2109-050-SUB5-PLANS_review

Correction Responses – 1/24/2024

SH2.0

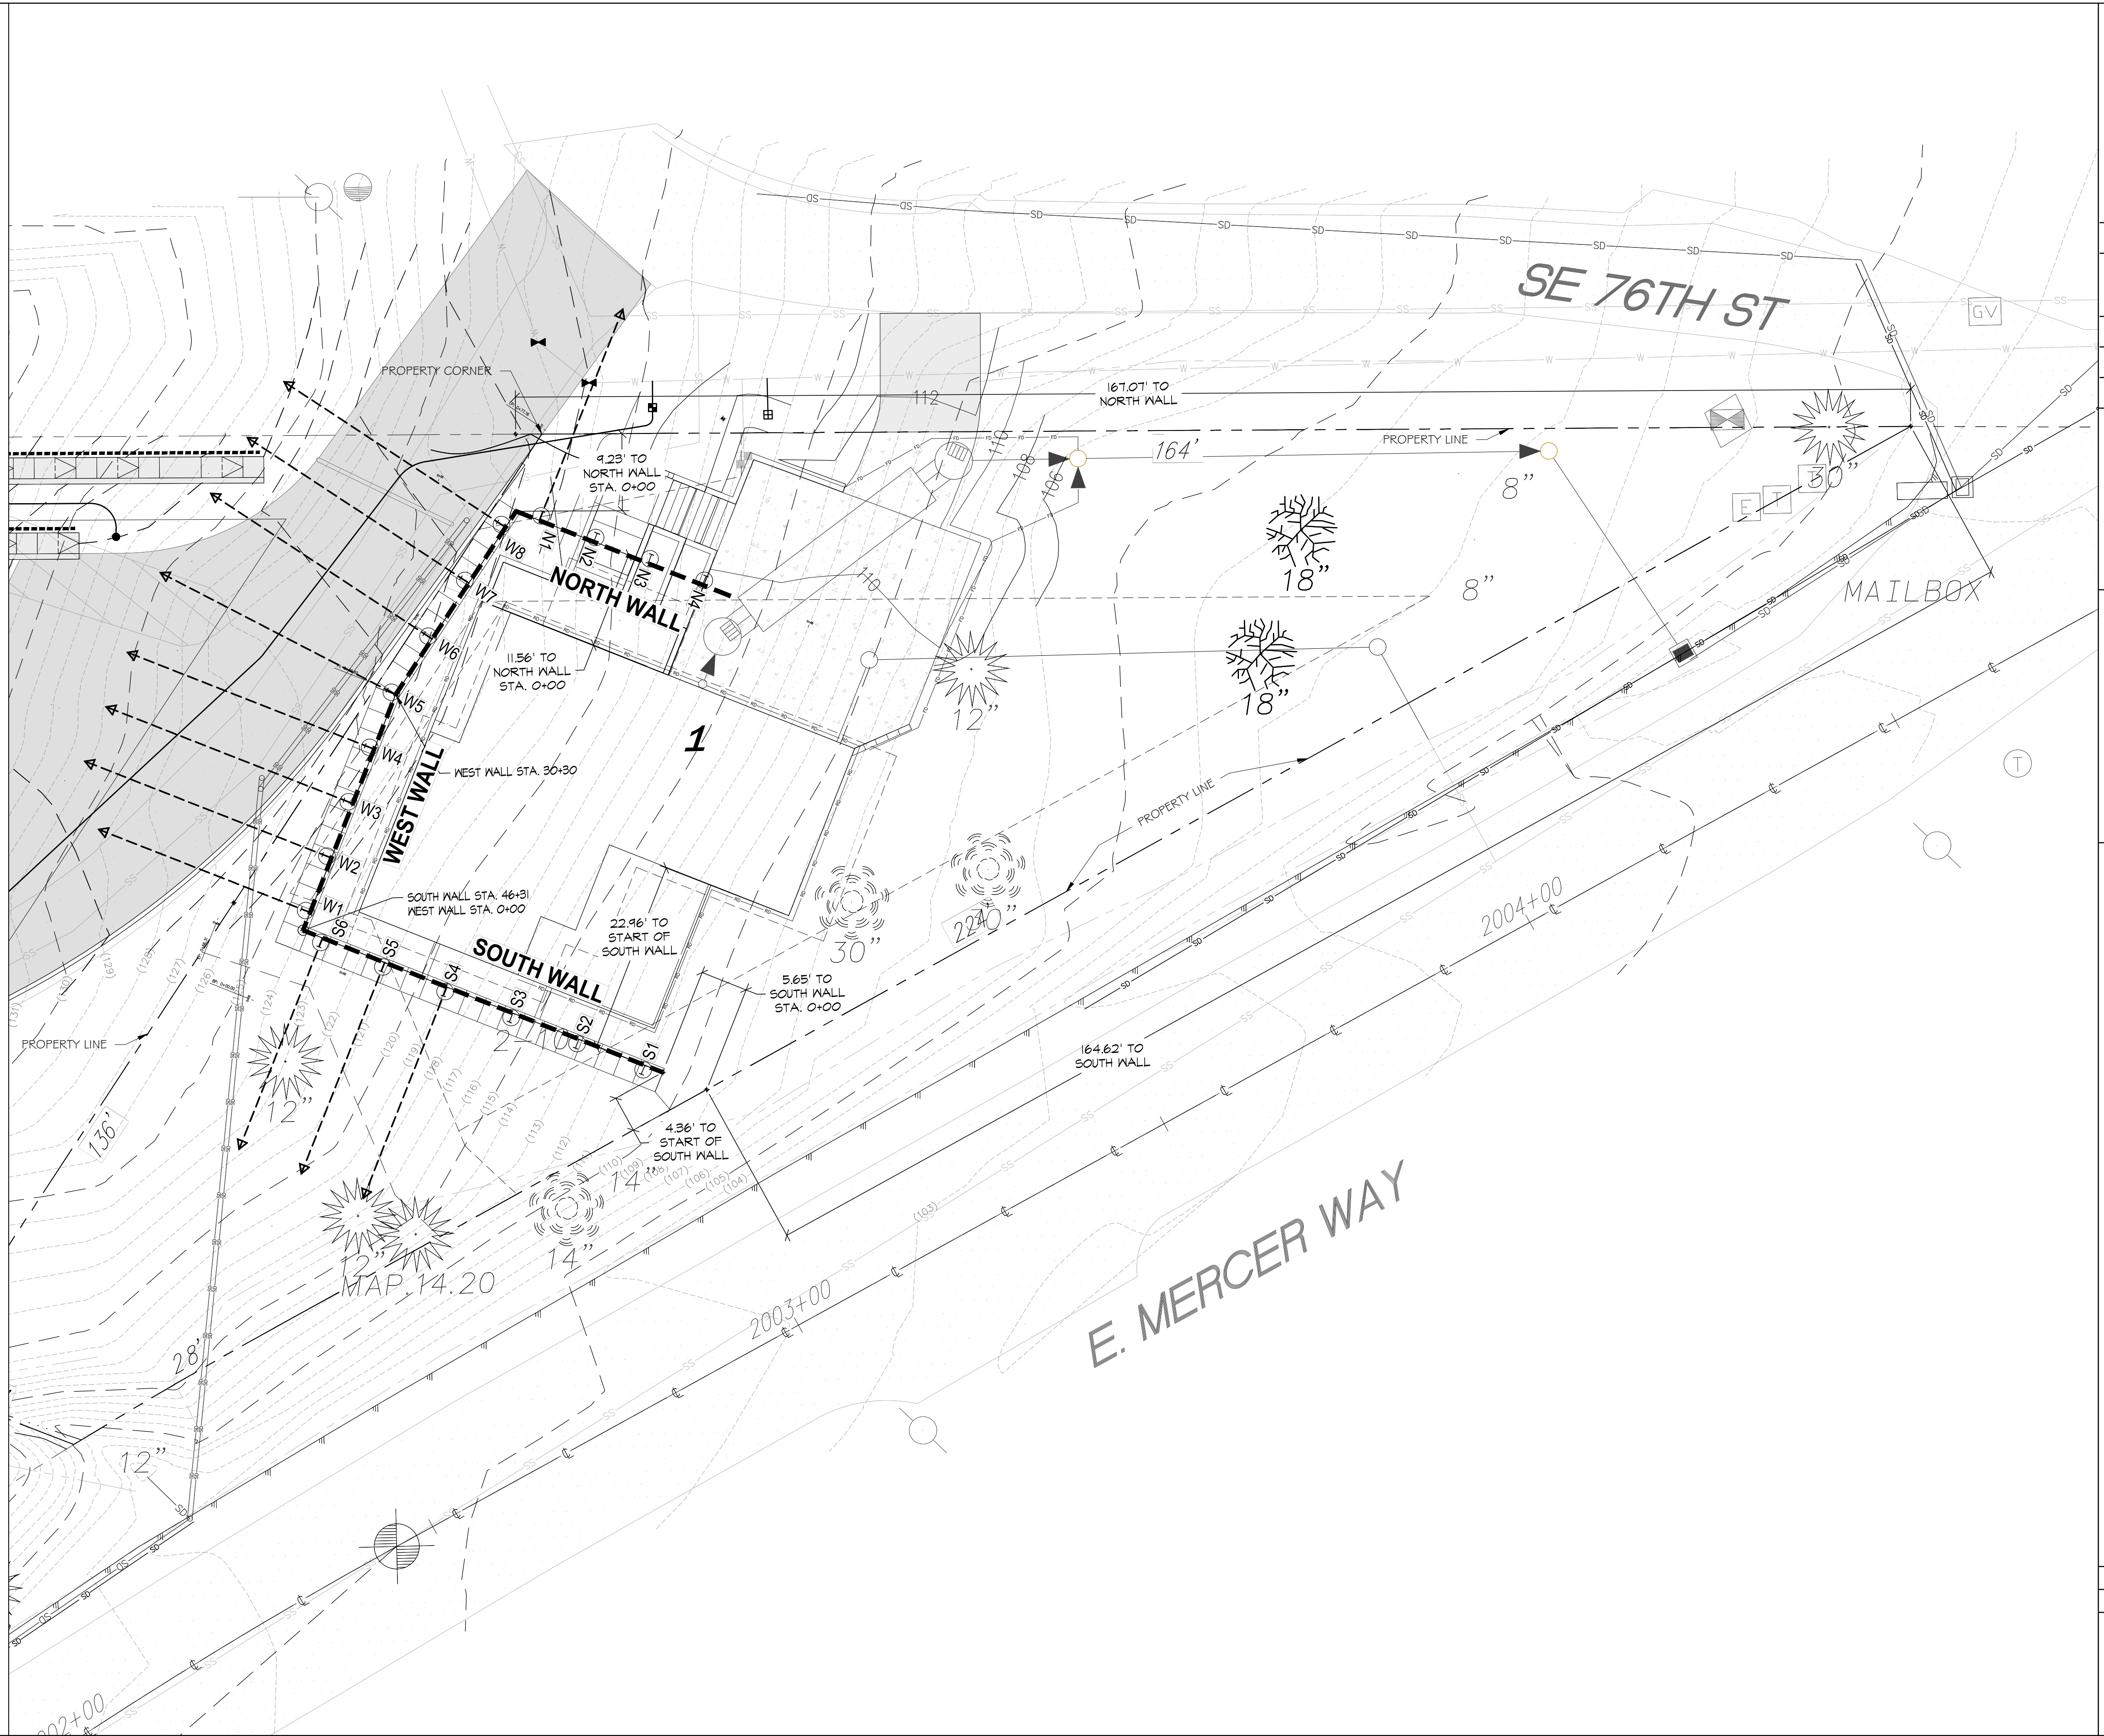
Building Plan Review: W7, W8, N1 anchors extend over the Property line and into the Right of way. Please revise the design for anchors not to protrude over property line.

Correction Response: Anchor design has been revised so no anchor will be placed in the ROW. See revisions clouded on Plan Set Sheets (SH1.1, SH2.0, SH3.1, SH3.2, SH3.A, SH5.5) and Shoring Calculation and Memorandum document (pgs. 7-8,10-11). A note has also been added to SH2.0: “No Temporary Tie-backs are Within the Public Right-of-Way”.

Anchors W7, W8 and N1 have been shortened. W8 has been reverted to a steep bar anchor (that permits the use of a shorter minimum un-bond length) and is using a higher bond strength. This keeps the W8 anchor out of the ROW. For N1, the small anchored soldier pile formerly shown has been replaced with a longer and much heavier cantilevered soldier pile. This keeps the N1 anchor out of the ROW.
